Rezoning Transportation Analysis
Petition Number: Insert Zoning Petition #2020-181
General Location Identifier: 11122105

Revision Log:

Date	Description
01-21-21	First Review (WB)
02-15-21	Second Review (WB)
04-23-21	Third Review (WB)
05-27-21	Fourth Review (WB)
09-28-21	Fifth Review (BKB)
10-13-21	Sixth Review (BKB)

REZONING PLAN

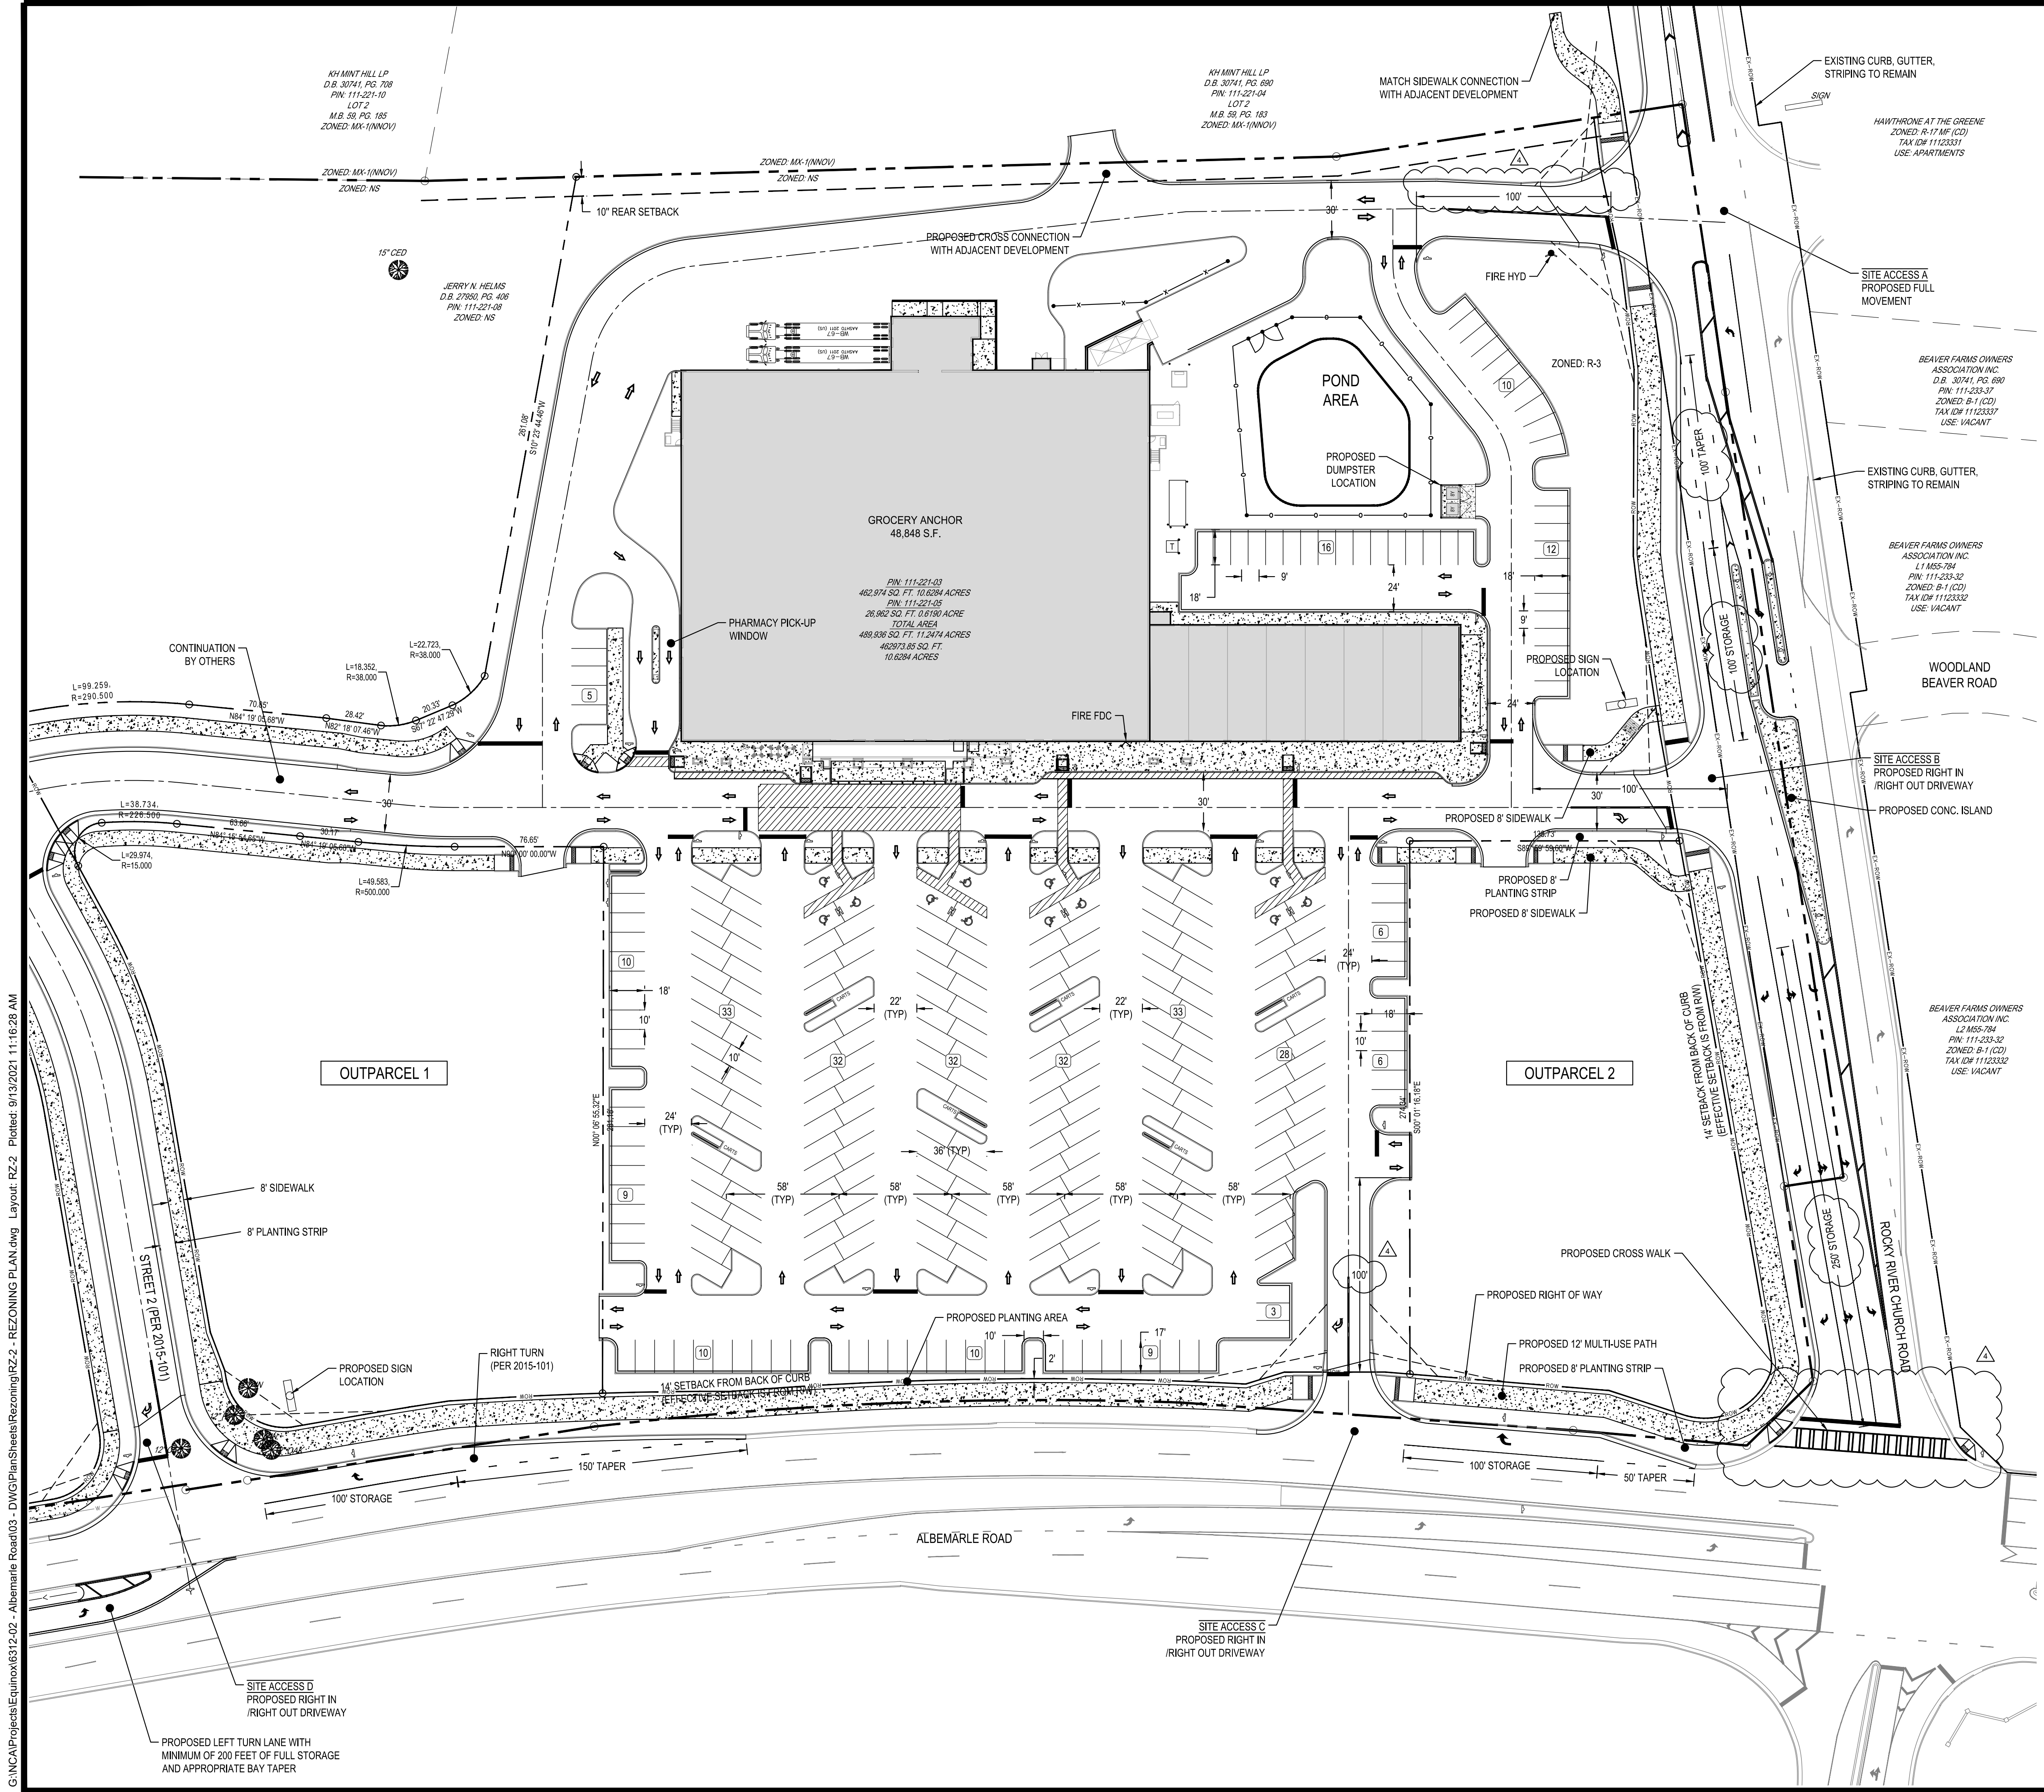
2. New Comments from NCDOT.

- a. R/W line should be straight along the Albemarle Road frontage. Remove the taper.
- b. Revise site plan and conditional notes to reserve an additional 12' right-of-way along the frontage of Rocky River Church Road to accommodate a future roadway widening.

4. **Comment Revised (based on Comment review meeting held on 2/5/2021).**
 Revise site plan to label and dimension the dedicated the Public Street right of way 2 per Rezoning Petition 2020-101. Street 3 will be constructed as a private street; however, the petitioner shall provide pedestrian connectivity on the south side of the proposed street. The site plan shall label and dimension an 8-foot planting strip and an 8-foot sidewalk on Street 2 and on the south side of Street 3.
